Ribble Valley Borough Council
Housing & Development Control

Your ref: 3/2024/0029
Our ref: D3.2024.0029
Date: 24th May 2024

Application no: **3/2024/0029**

Address: **5 The Dene Hurst Green BB7 9QF**

Drwg No
1424-PL06E

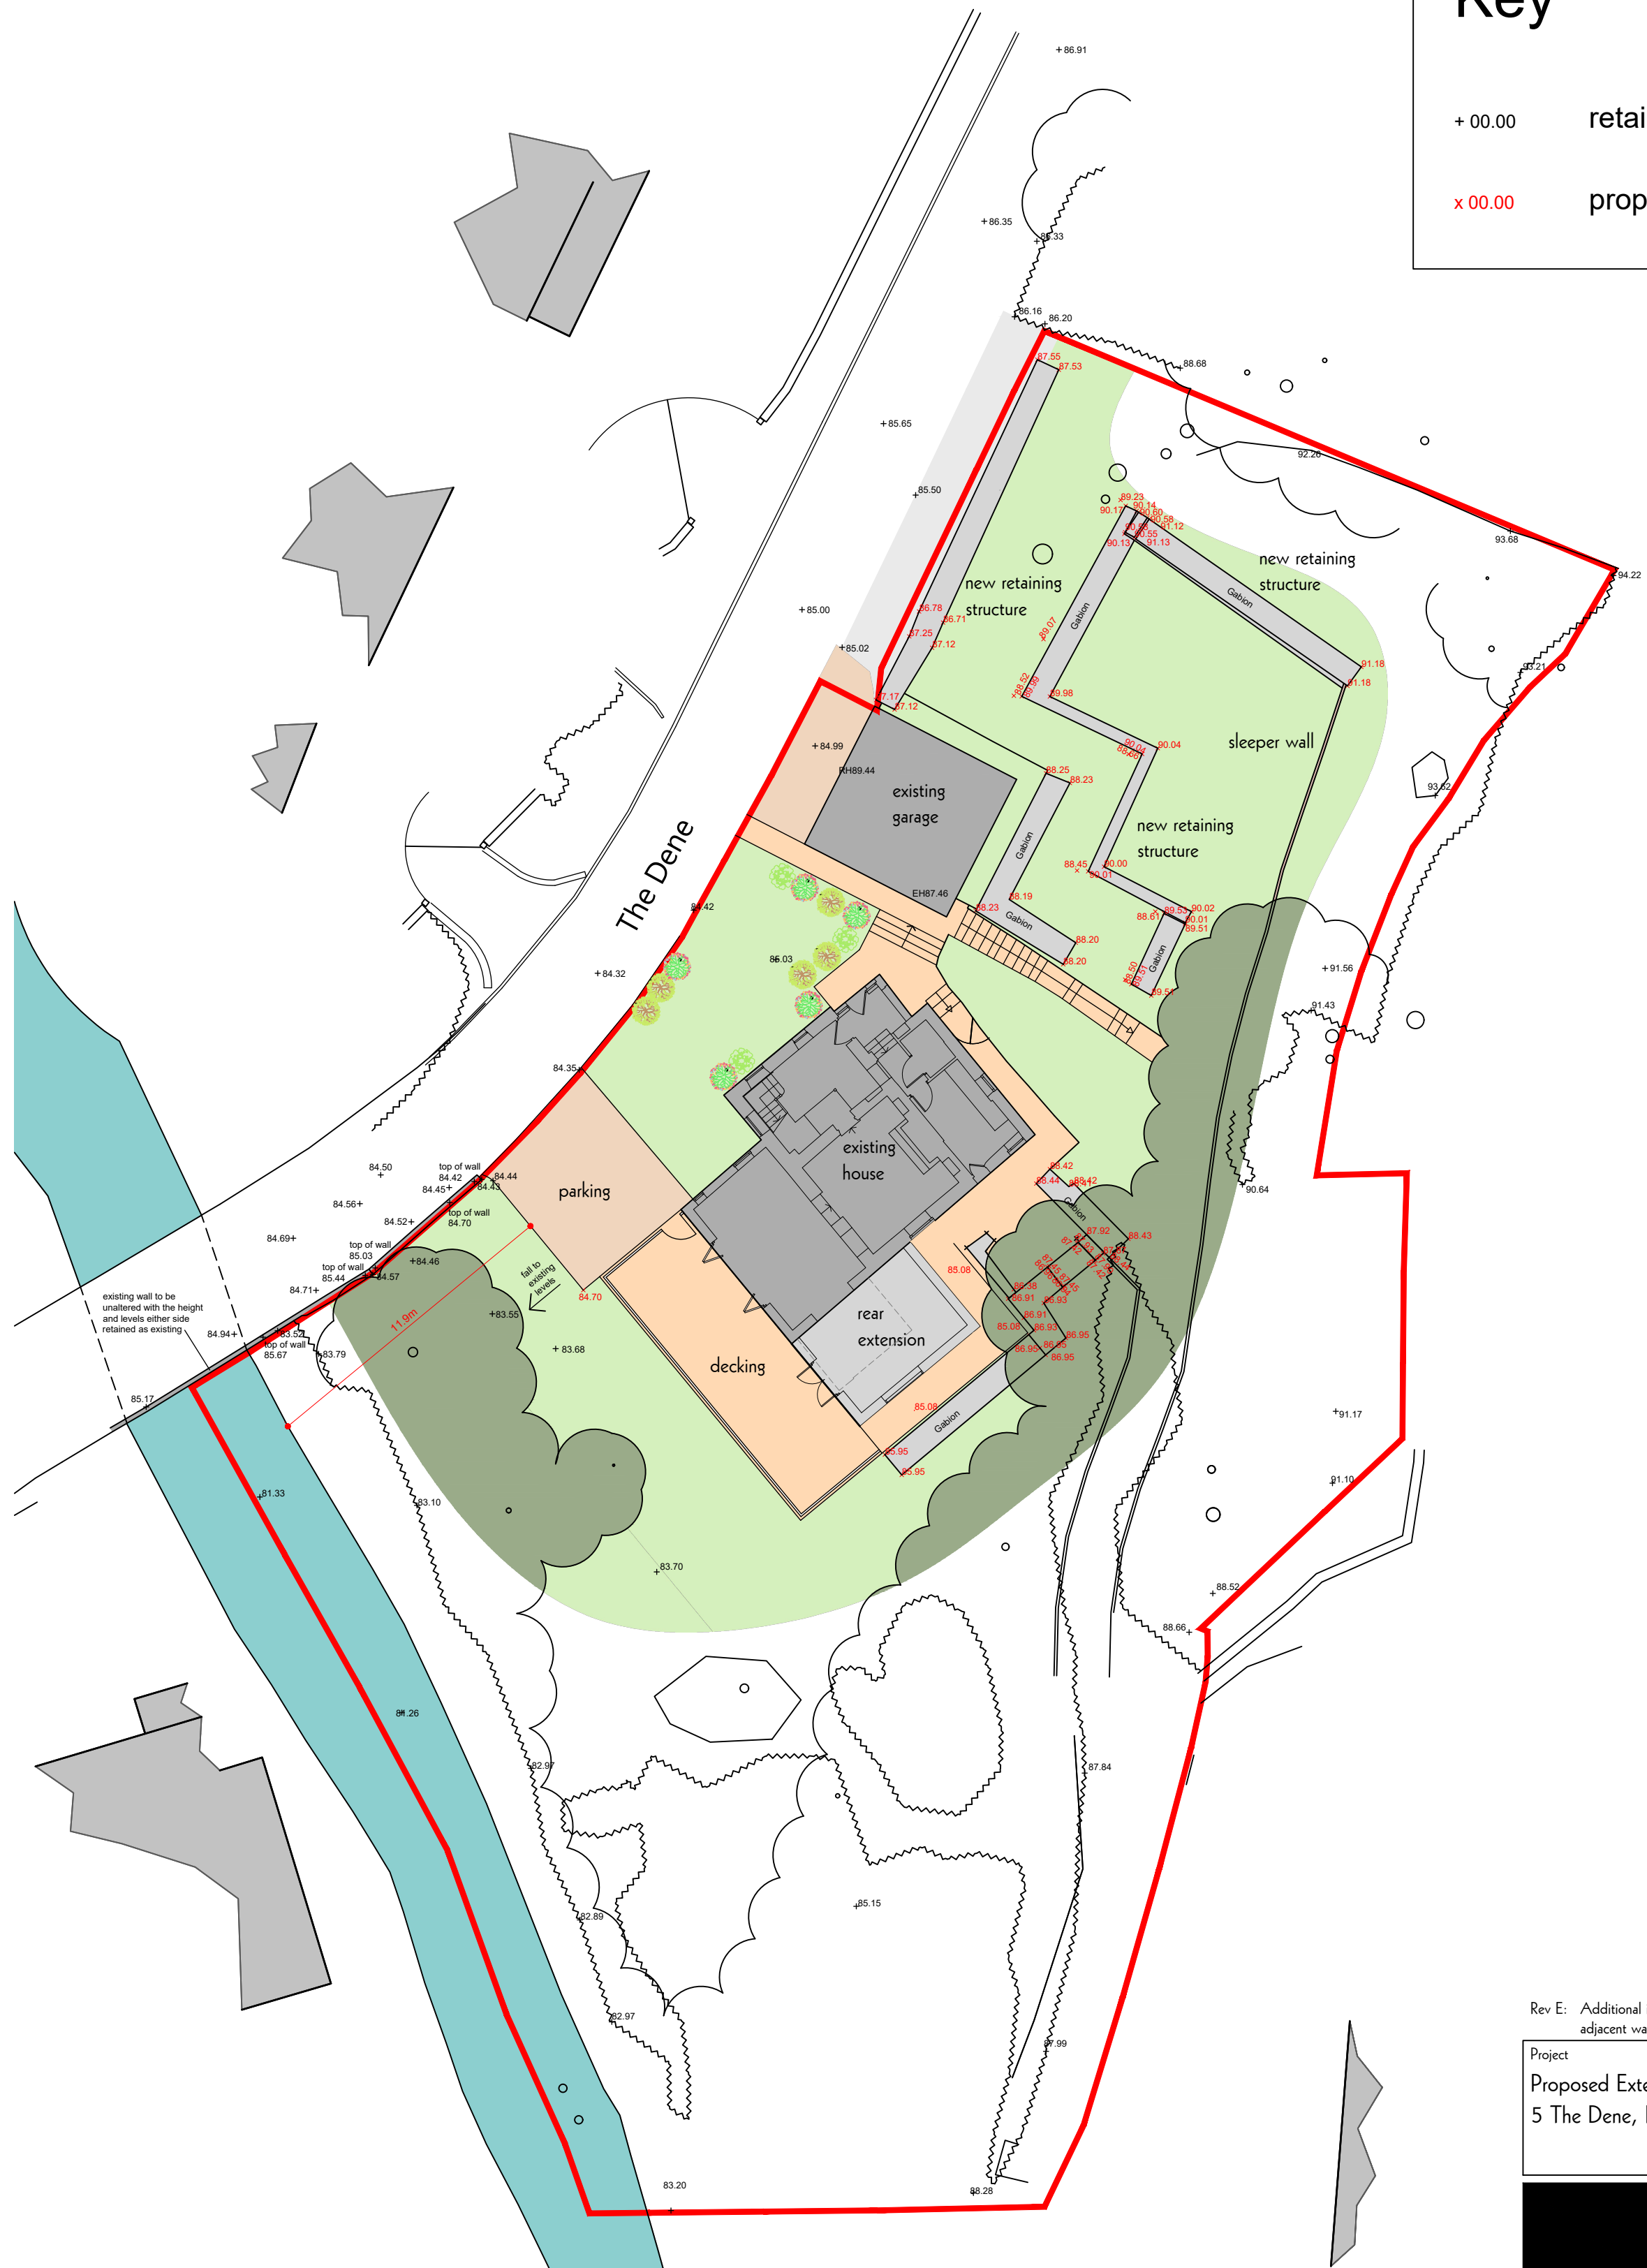
The LHA have reviewed PNL drawing number 1424-PL06D titled "Proposed Site Layout" and while the proposed parking area complies with the LHAs guidance when providing two car parking spaces, the LHA still require further information. This is because the parking area will be located adjacent to the bridge, named Dene, which is owned by Lancashire County Council. As a result, works are likely to occur adjacent to the parapet of the bridge, meaning that the LHA will require further information to ensure that the works will not destabilise the structure of the bridge. Therefore, the following information needs to be submitted:

- Detailed drawing showing the location of the parapet in relation to the parking area.
- Existing and proposed levels of the parapet.
- Existing and proposed levels of the parking area.
- Whether there will be any retaining structures adjacent to the parapet?

To prevent the Agent/ Applicant in undertaking this substantial amount of work, the LHA advise that the parking area is relocated adjacent to the garage, on the existing/ proposed grassed area as shown on PNL drawing number 1424-PL06D. The area appears to have the adequate dimensions to provide a minimum of two car parking spaces. Therefore, the LHA advise that a revised plan is submitted showing this.

The LHA require further information before the LHA can fully assess the application. The LHA either require detailed plans, as requested above to be submitted, showing the parapet of the bridge and the proposed and existing levels of the parapet and the parking area. Or a revised plan to be submitted, showing the parking area being relocated adjacent to the garage on the grassed area, as shown on PNL drawing number 1424-PL06D.
